DRB Application No.: 05DRB-01830 (SPS)

Project Name: VENTANA SQUARE @ VENTANA RANCH

**DEVELOPMENT REVIEW BOARD
ACTION SHEET**

TO: Sheran Matson, DRB Chair
FROM: Carmen Marrone, Senior Planner
RE: **Project #1002346, Ventana Square**

TRACT Z
AMAFCA
DRAINAGE
FACILITY

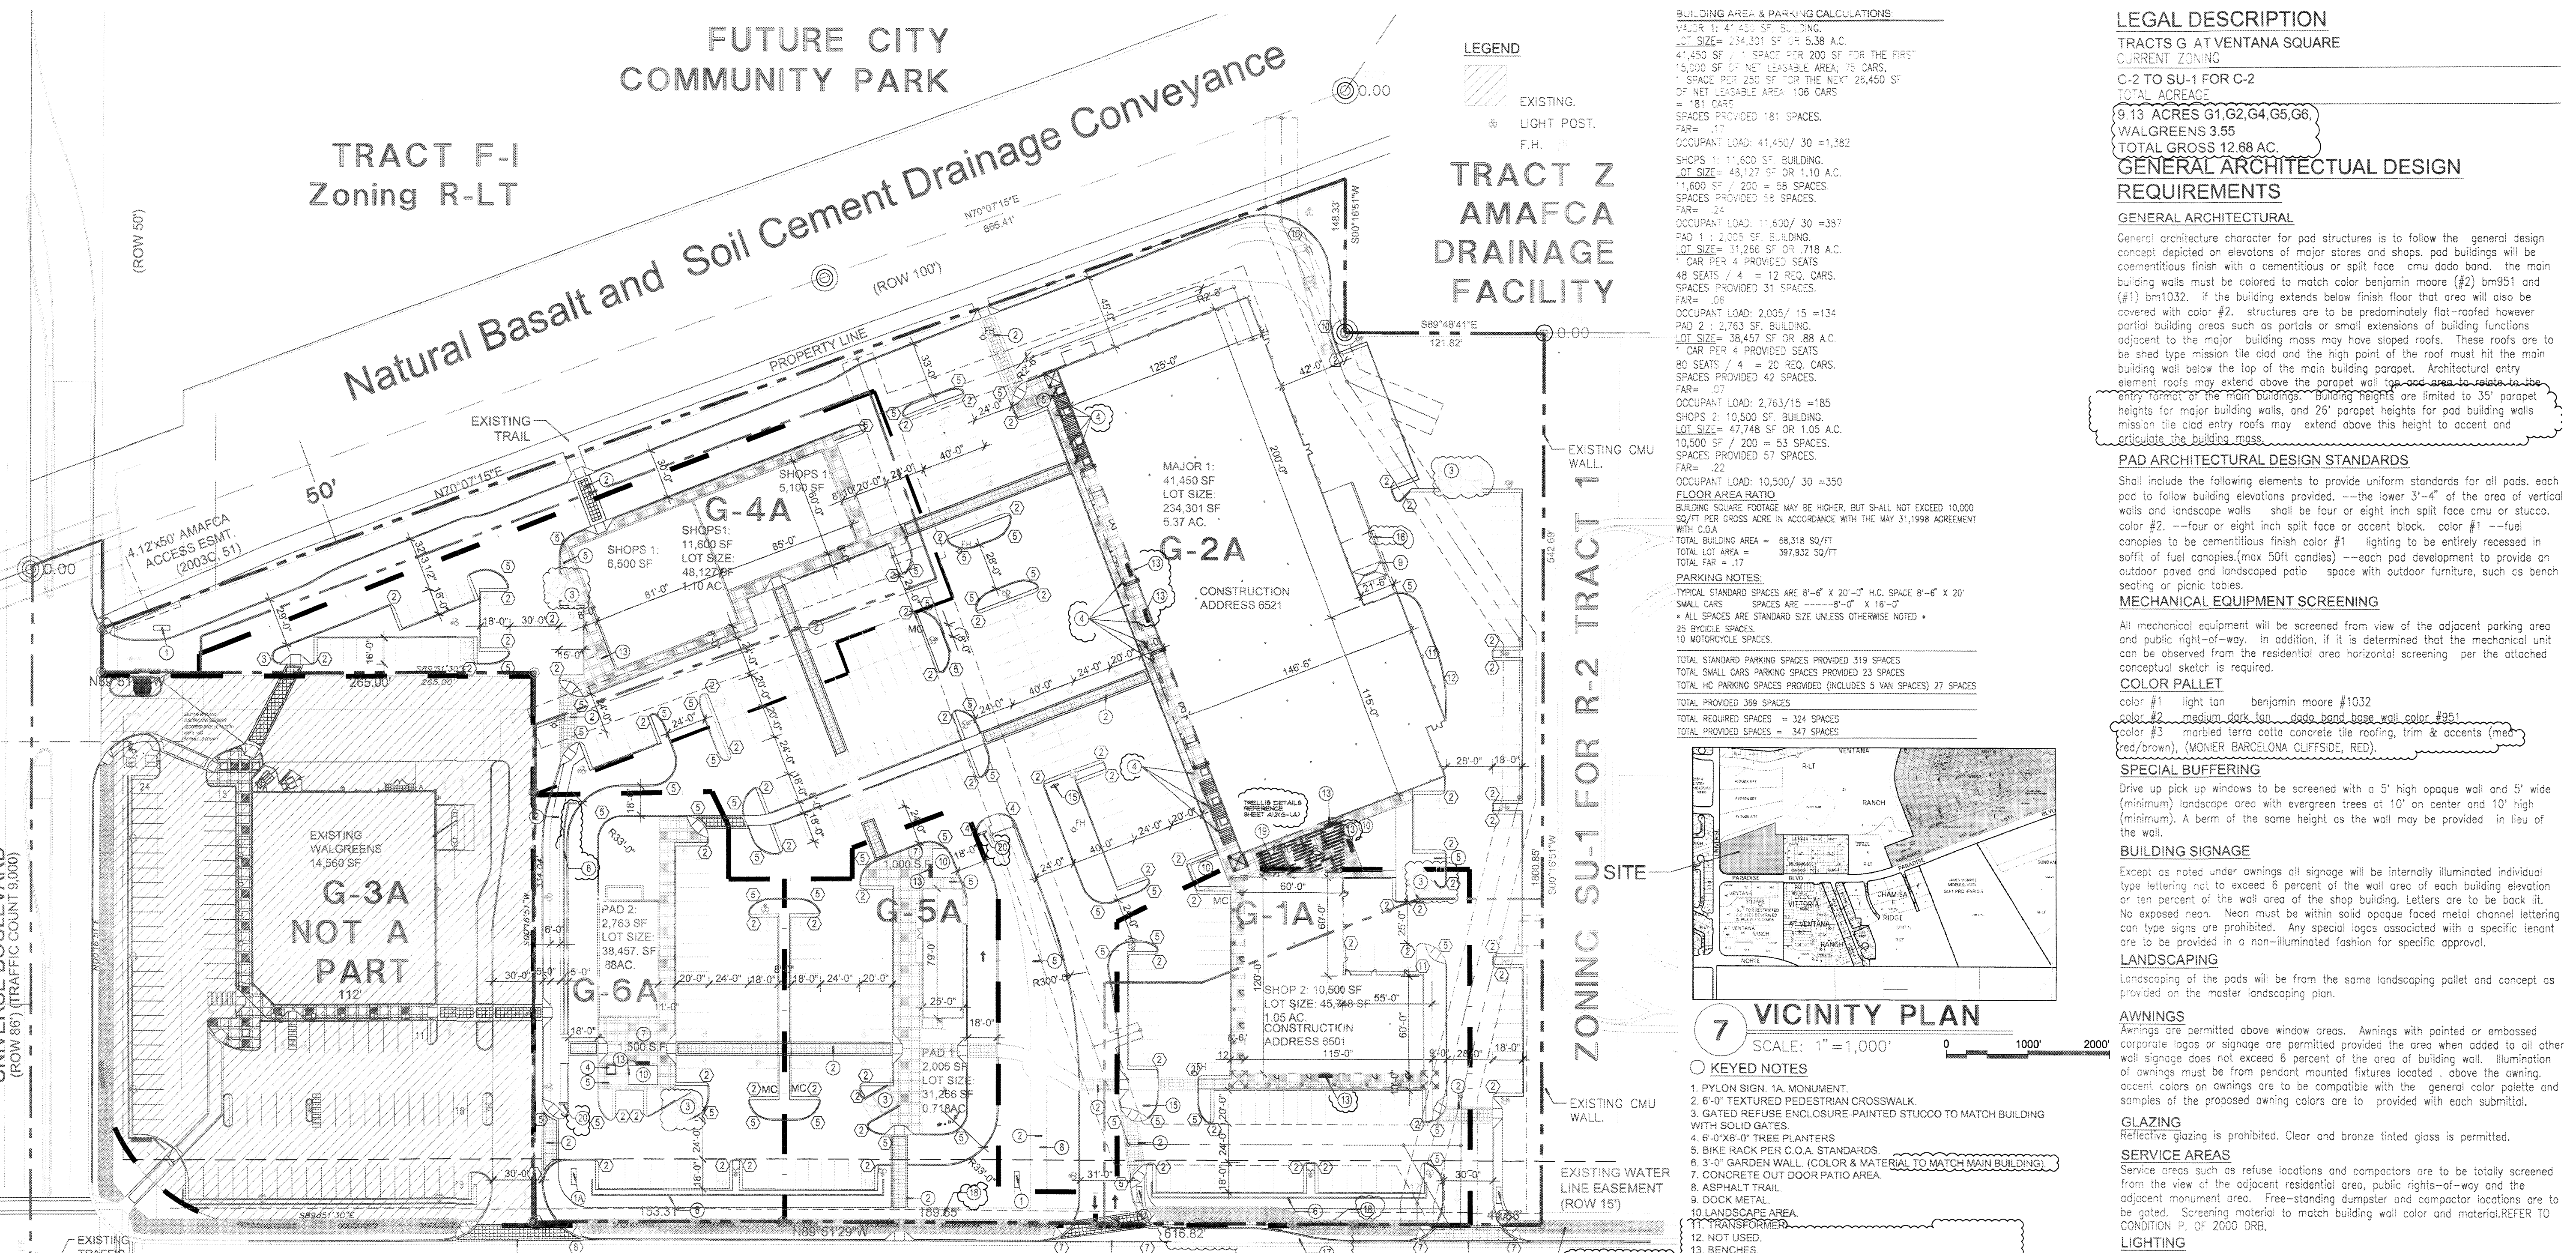
1. Need a DRB signature block
2. The site plan, notes and calculations need to be updated to be consistent with the site plan for building permit.
3. The total acreage needs to be corrected (12.68 acres)

DATE: 11/15/2005 sheet
 SCALE: 1"=50' G-1A & G-2A of

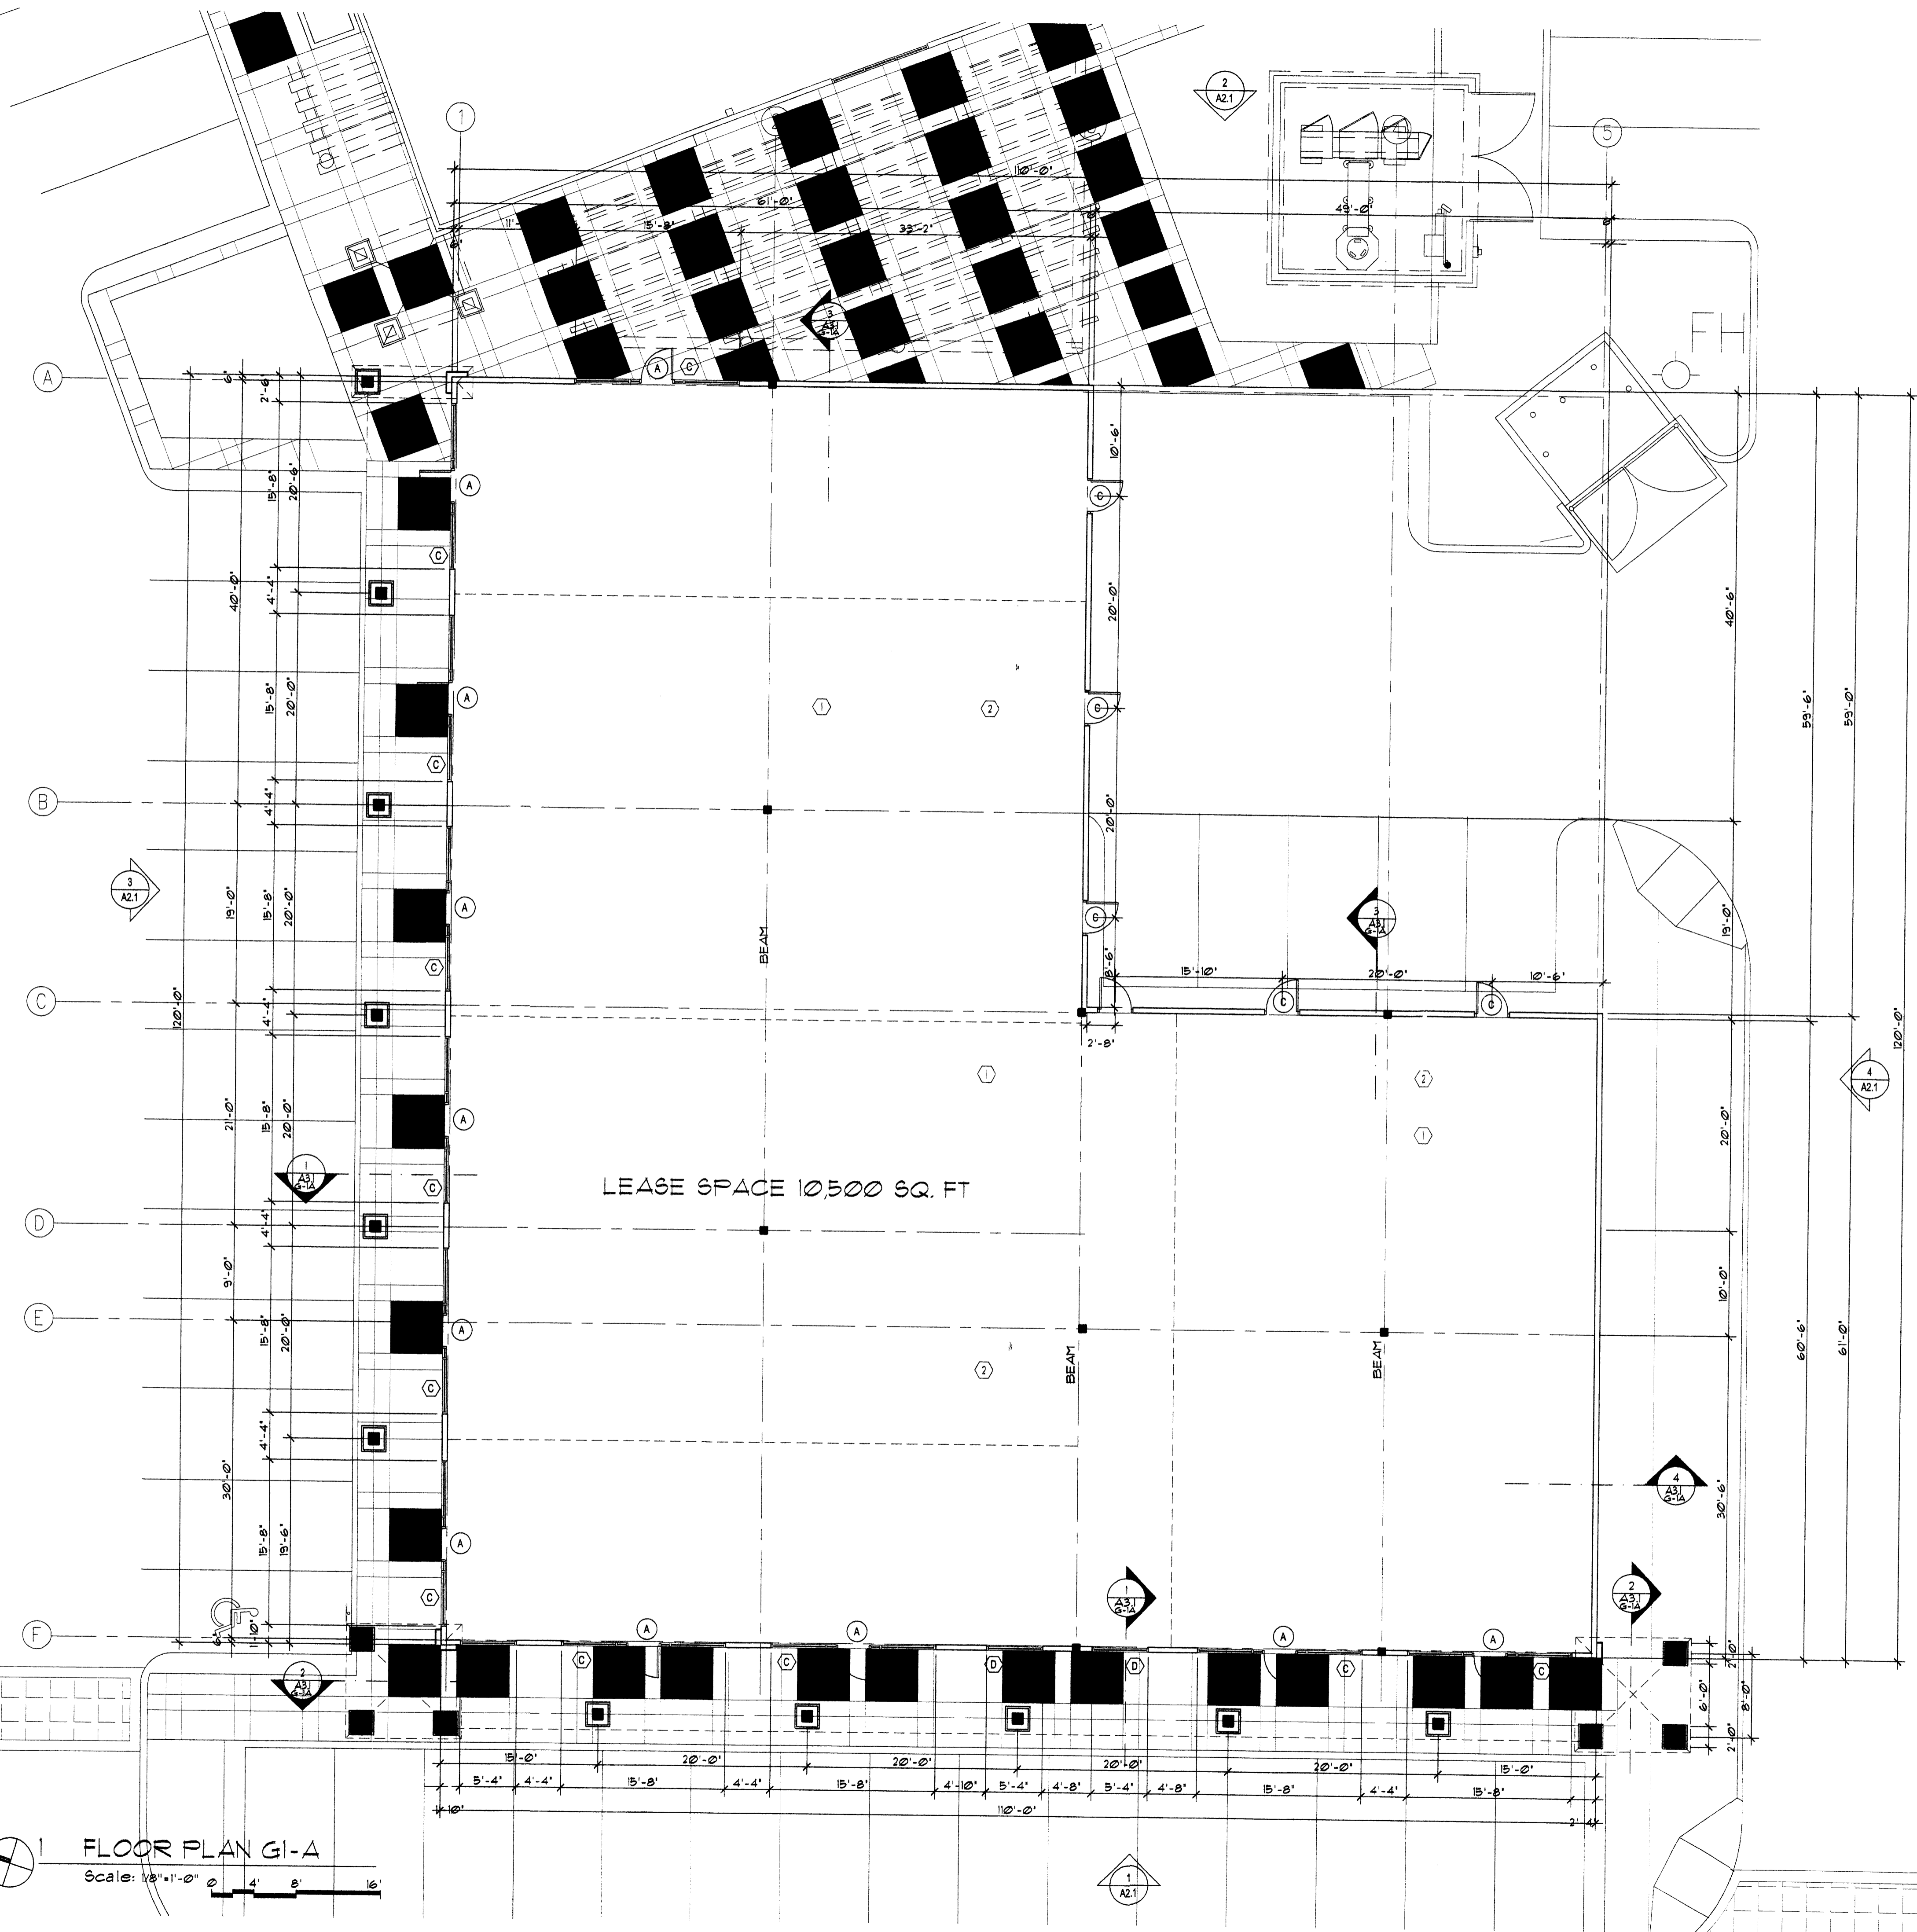
Condition 15: One additional shade tree should be provided in the patio area north of Pad 1 Building.

Condition 16: Provide additional seating in the patio between Major 1 and Shop 2 buildings.
